Reference: PA-0002254/01
Customer reference: H09-0306-26

28 April 2026

**Erection of ground mounted solar array & associated works
Bakkavor, Sluice Road, Spalding PE12 8HF**

Client		Bakkavor	
Project Title			
Solar Project			
Drawing Title			
Proposed Ground Layout - 3D and section			
Scale (@ A1)	Date		
1 : 100	Jan 2026		
Drawing No.	Drawn	REV	
368_07	MJF	A

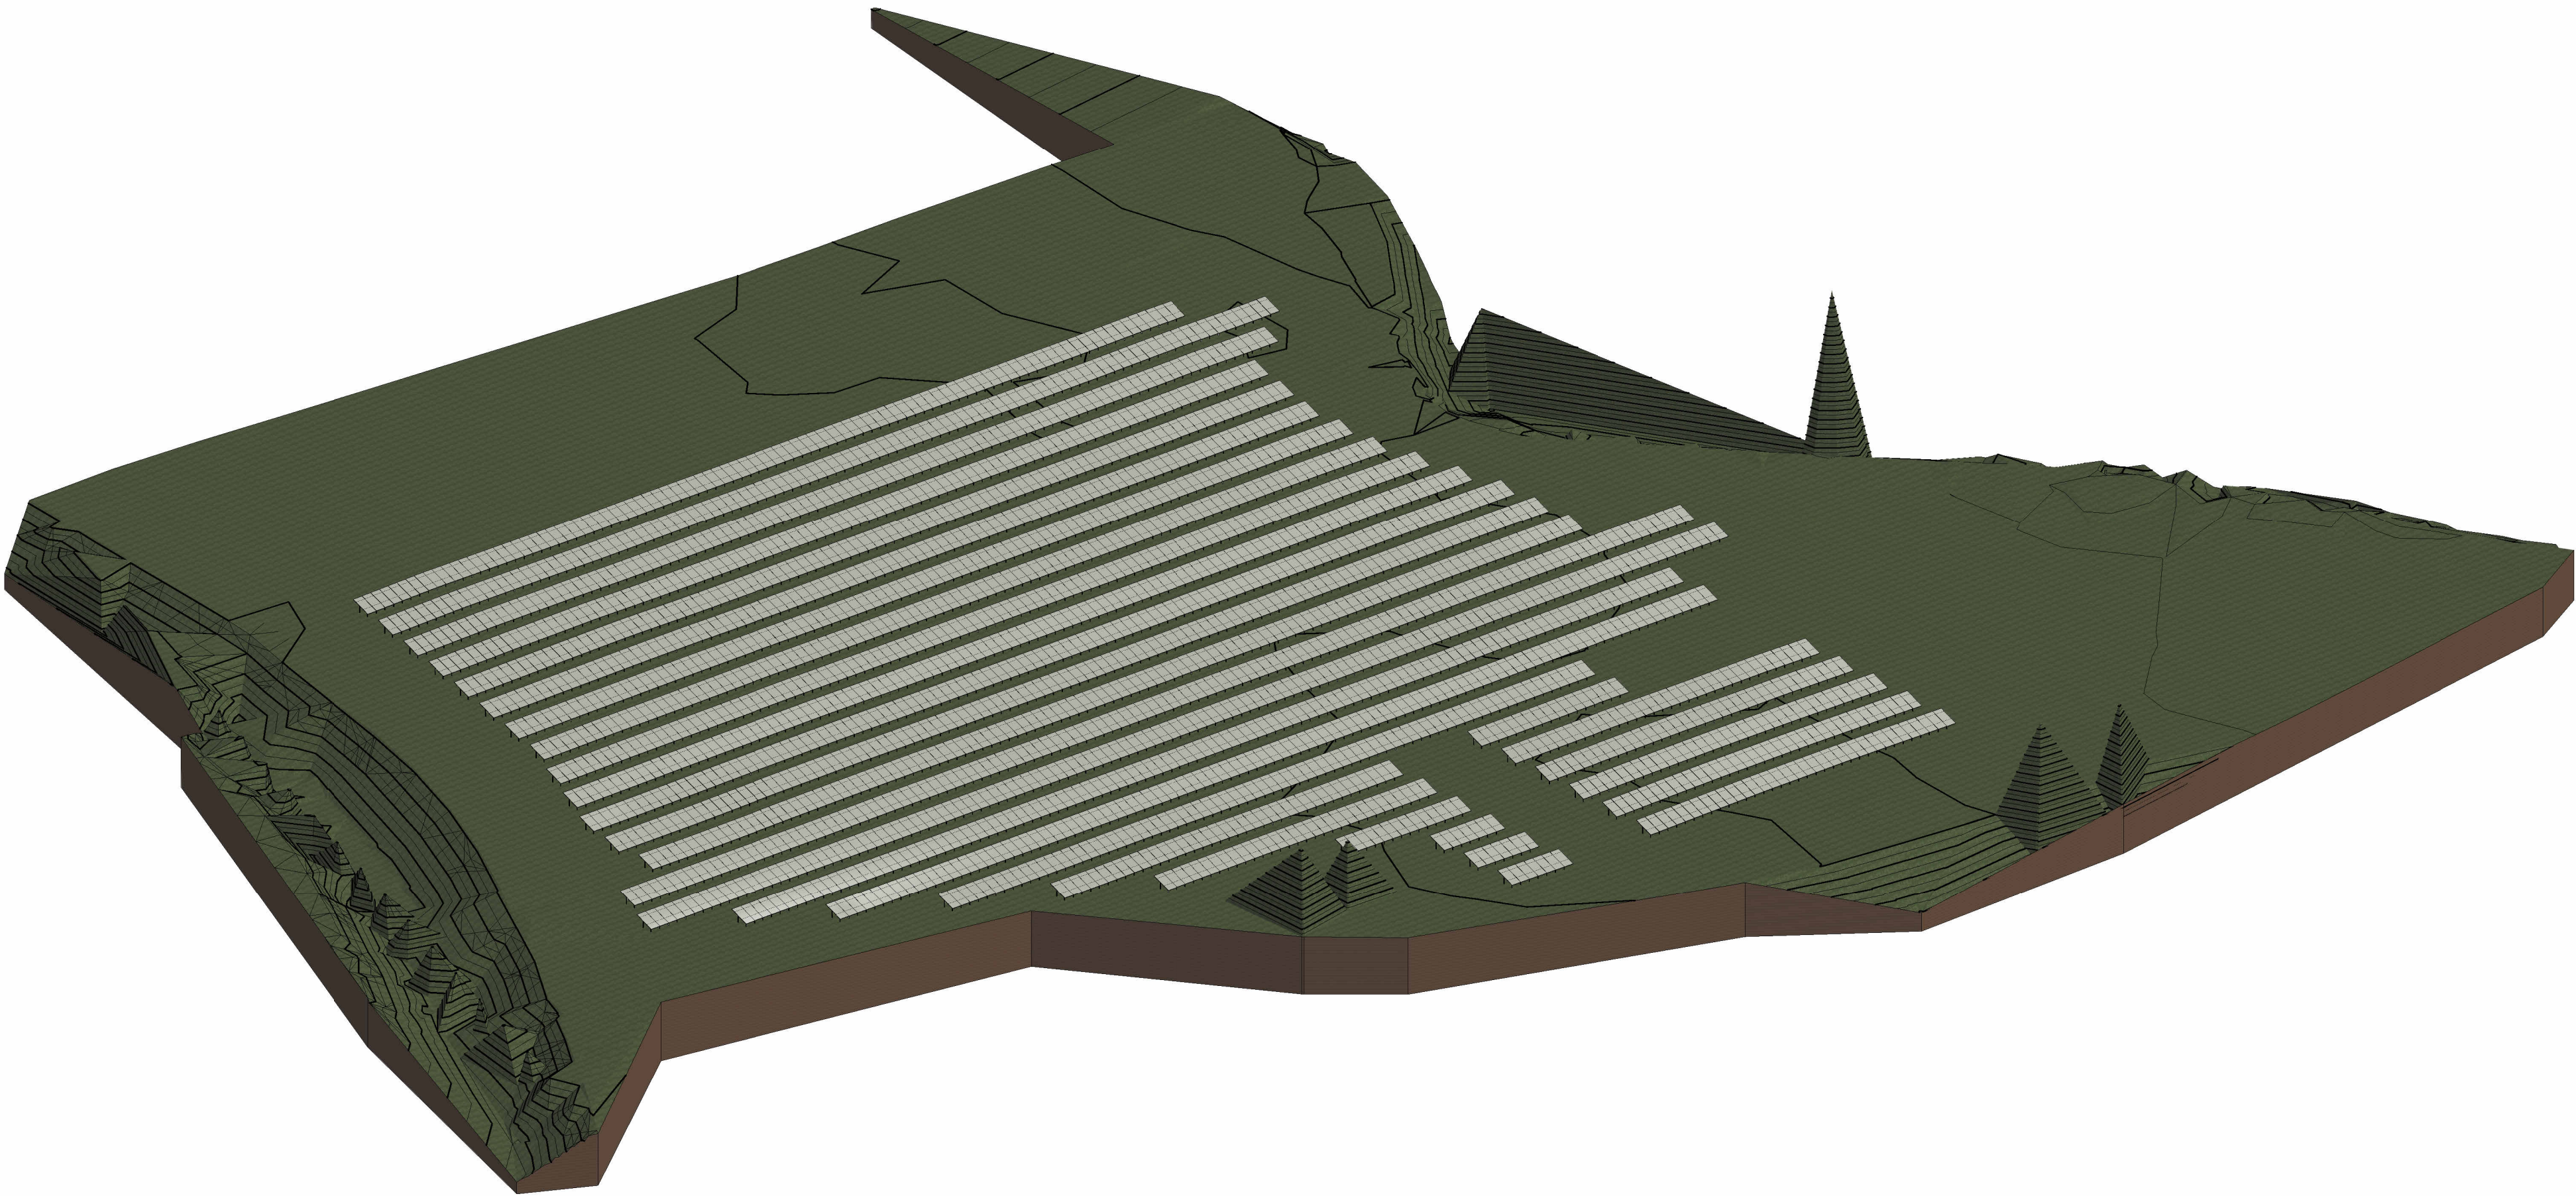
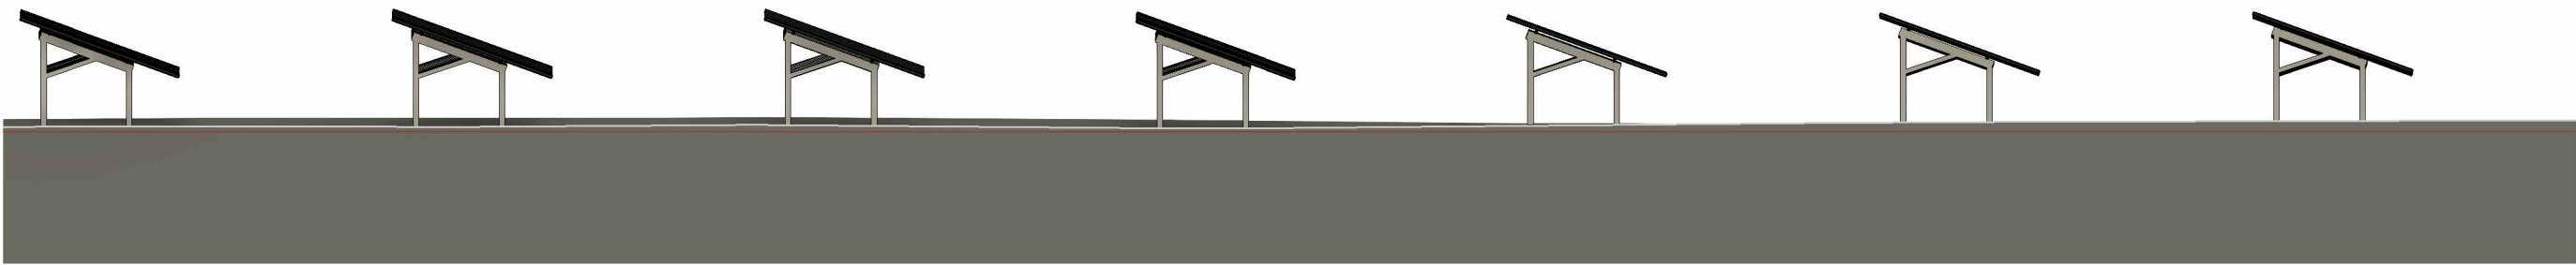
The submitted FRA proposes to raise the electrical equipment located within the hazard breach extent by 0.5m and proposes to raise the solar panels located within 0-0.25m flood depths by 0.55m above the ground level.

Considering this, we do not wish to raise an objection to this application, subject to the imposition of the following condition. However, we note that the extent of equipment needing raising may increase to the west of the site where the 2115 0.5% breach maps show no depths.

The solar PV panels and electrical equipment shall be raised above the predicted flood depths, shown on the Environment Agency 2115 0.1% tidal breach flood maps contained in the flood risk assessment ref: 25-3269-KTN-FRA-01-B, equivalent to a minimum of 4.5m above Ordnance Datum. This mitigation measure shall be fully implemented prior to operation and subsequently shall be retained and maintained thereafter throughout the lifetime of the development.
